KIRKLEES METROPOLITAN COUNCIL INVESTMENT & REGENERATION SERVICE

DELEGATED DECISION TO DETERMINE PLANNING APPLICATIONS

Reference No:	2025/62/92135/E
Site Address:	2, Hollybank Avenue, Upper Batley, Batley, WF17 0AQ
Description:	Erection of single storey rear extension, rear dormer, first floor balcony on front elevation enclosed with feature gable windows.
Recommending Officer:	Faiza Bano

OFFICER REPORT

Total RPA : 187 sqm  
RPA Encroached : 6 sqm  
% Encroached : 3.2 %

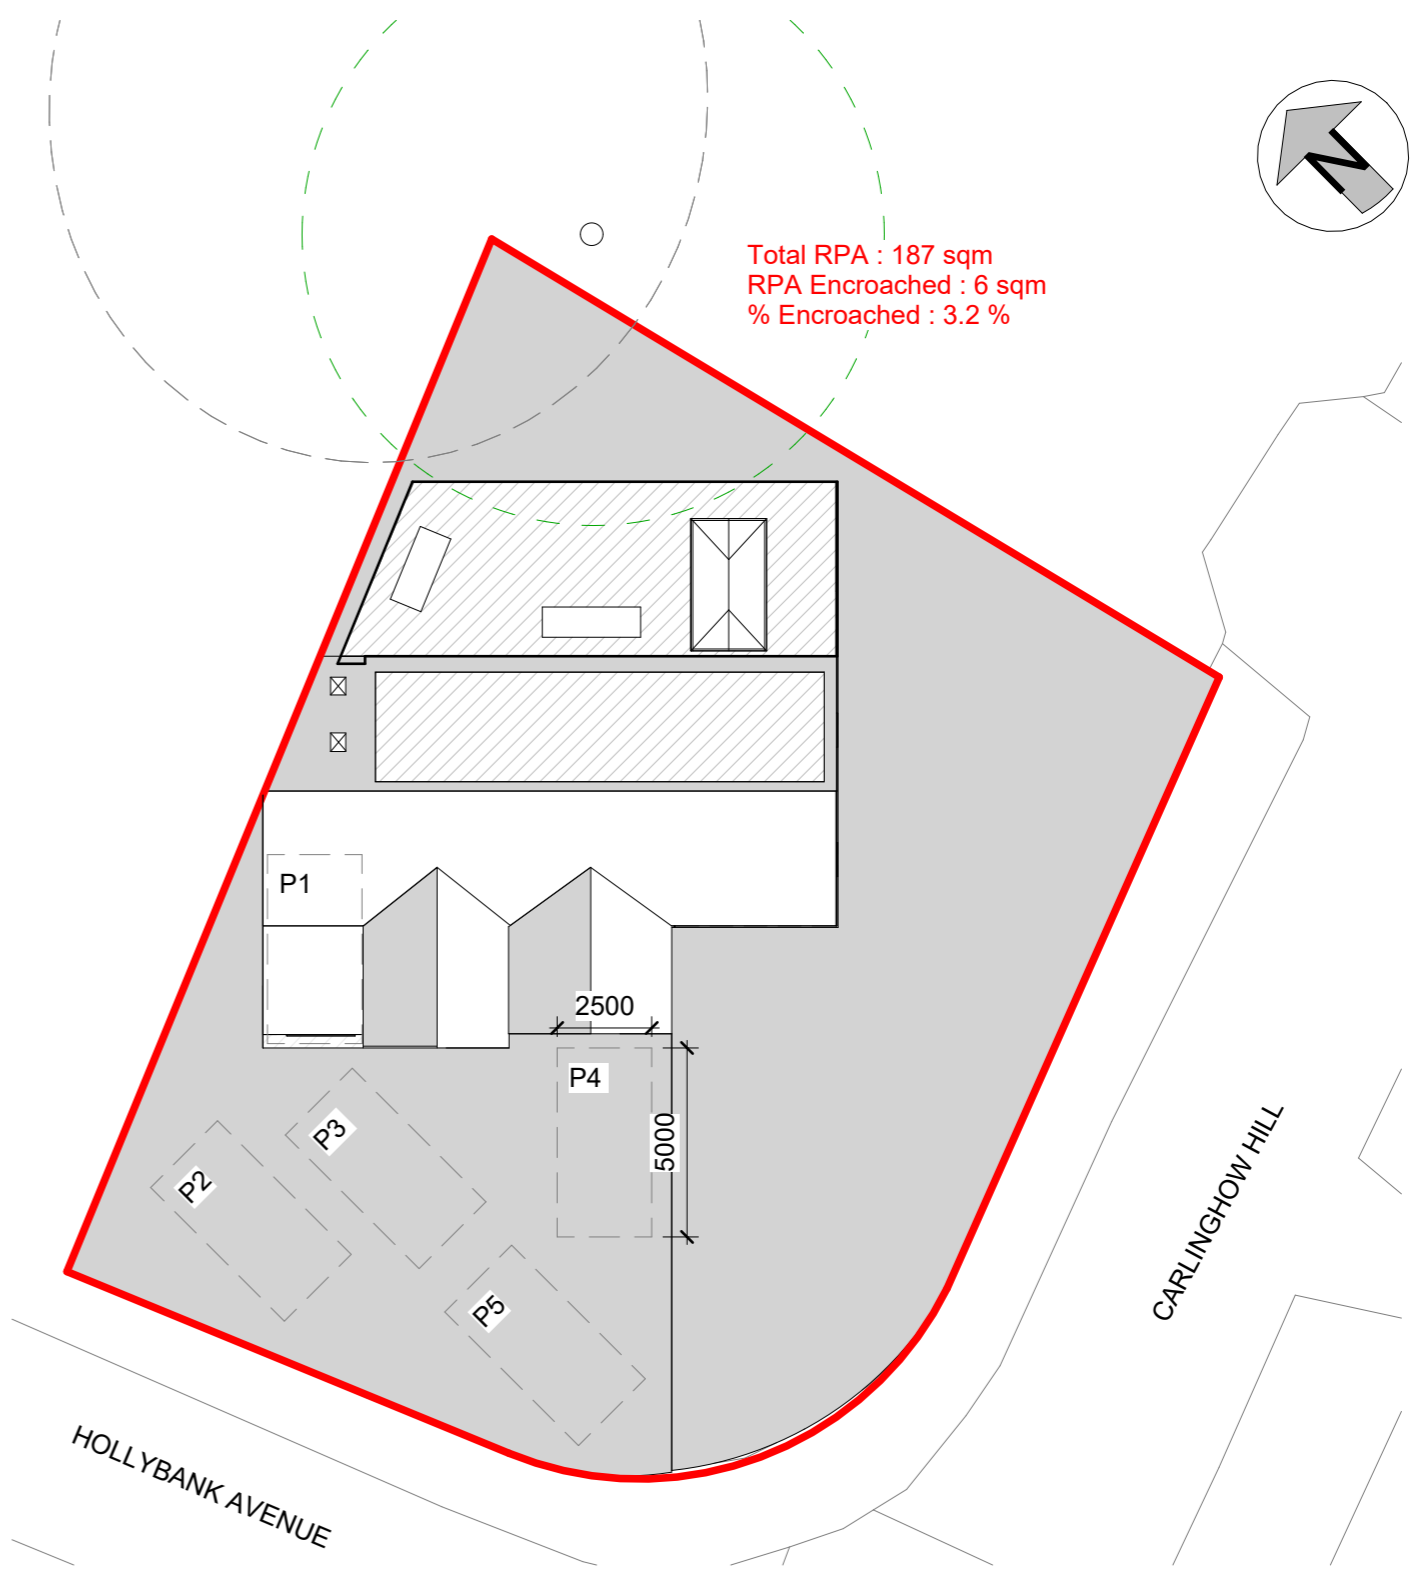
Following the consultation objection, the case officer sought further advice from the Council's Tree Team (KC Trees) to establish whether amendments could address the concerns raised. The Tree Team advised that they cannot support the proposals in their current form, as the proposed structure continues to pose

a direct and indirect threat to the protected trees. It was also noted that there is no overriding justification for the scale of the proposed extension.

The Tree Officer acknowledged that the submitted Arboricultural Method Statement (AMS) includes measures intended to mitigate impacts on the protected trees; however, it was emphasised that such impacts should be avoided in the first instance. To achieve this, the footprint of the extension would need to be reduced and repositioned further away from the tree-lined boundary to provide adequate separation between the development and the protected trees.

Amendments sought for a materially revised scheme that demonstrably and significantly reduces impact in principle and takes development outside the Root Protection Area.

The agent submitted plans that address site constraints, with particular regard to the Root Protection Areas of nearby trees. The proposed extension has been significantly reduced in scale to minimise its impact, resulting in the majority of the structure now being located outside of the RPAs. A minor incursion of approximately 3% into the RPA of Tree T008 remains, with no encroachment identified in relation to other retained trees.

**Proposed Ground Floor**  
1 : 100

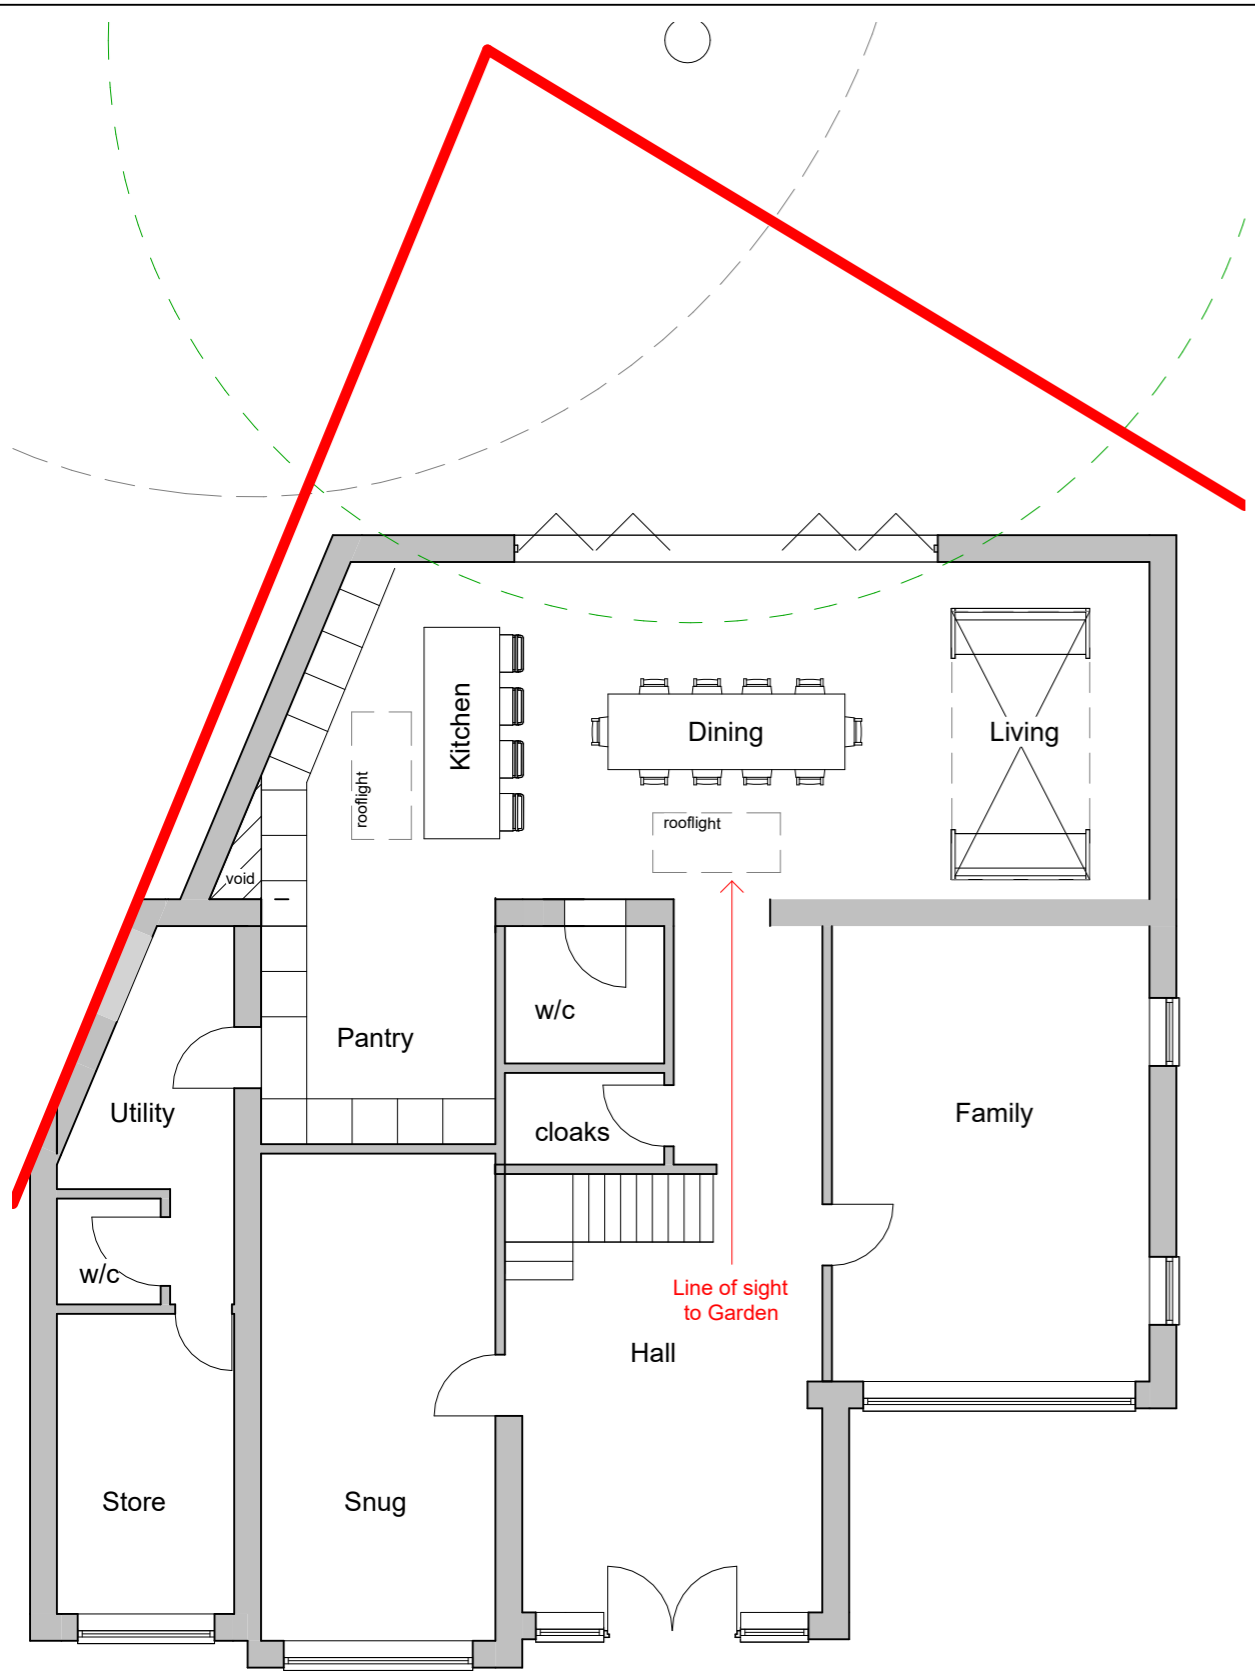
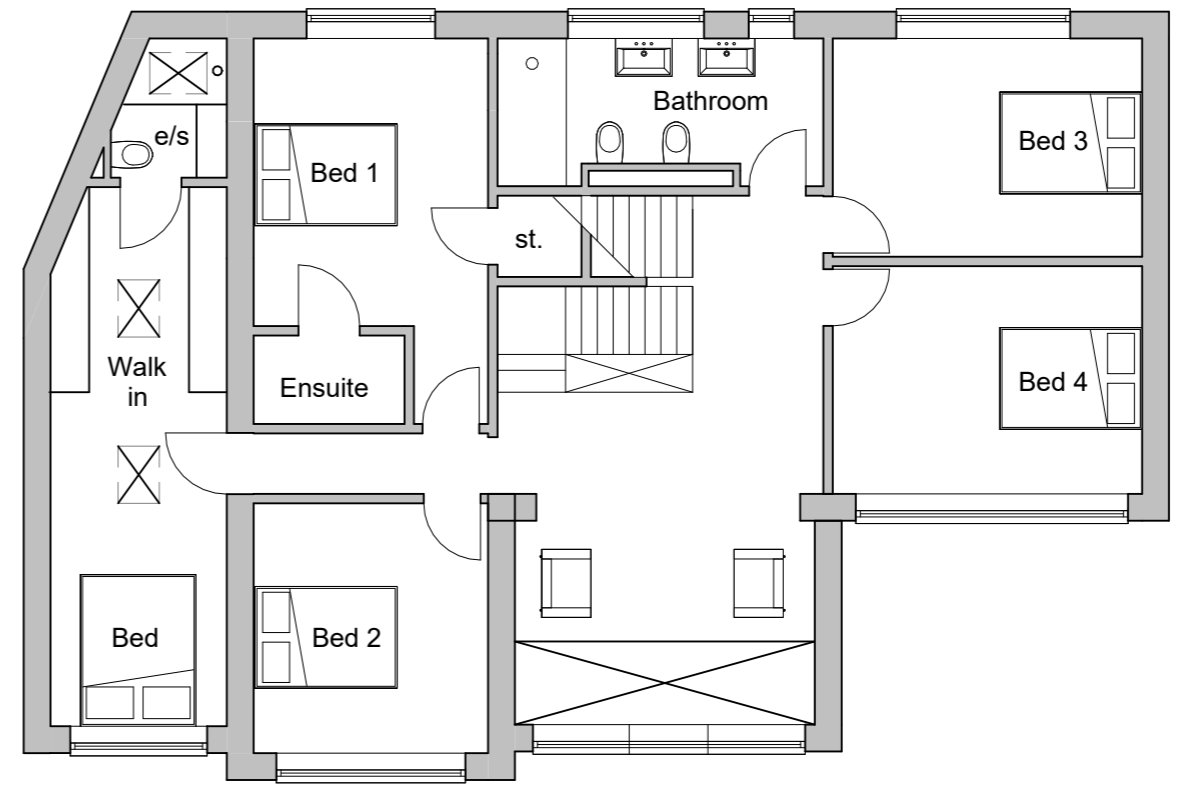
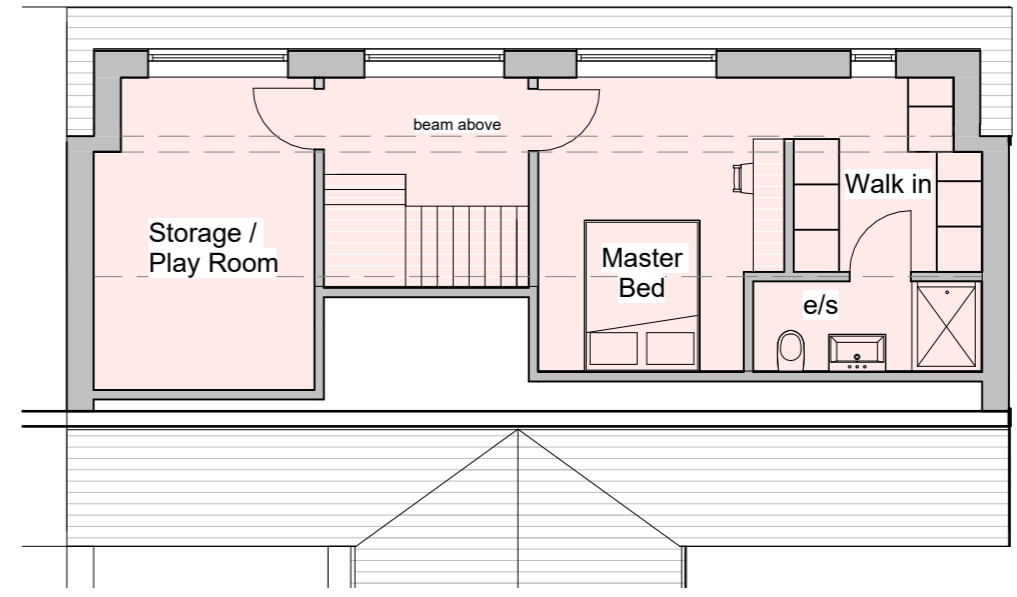
Amendments were requested to replace the grey tile with brickwork for consistency with the existing façade, reposition the proposed side wall to increase the distance from the shared boundary fence with the neighbouring property, and apply frosted glazing to the walk-in wardrobe window within the dormer. Agent has noted the request for an obscurely glazed window and is happy for this to be secured via a planning condition, if considered necessary.

With regards to the proposed ground floor rear extension, amended plans were received demonstrating that this element would no longer project past the rear elevation of the neighbour and would maintain an appropriate separation distance from the shared boundary. As such, it is not considered that it would result in a loss of daylight/sunlight nor would it appear overbearing.
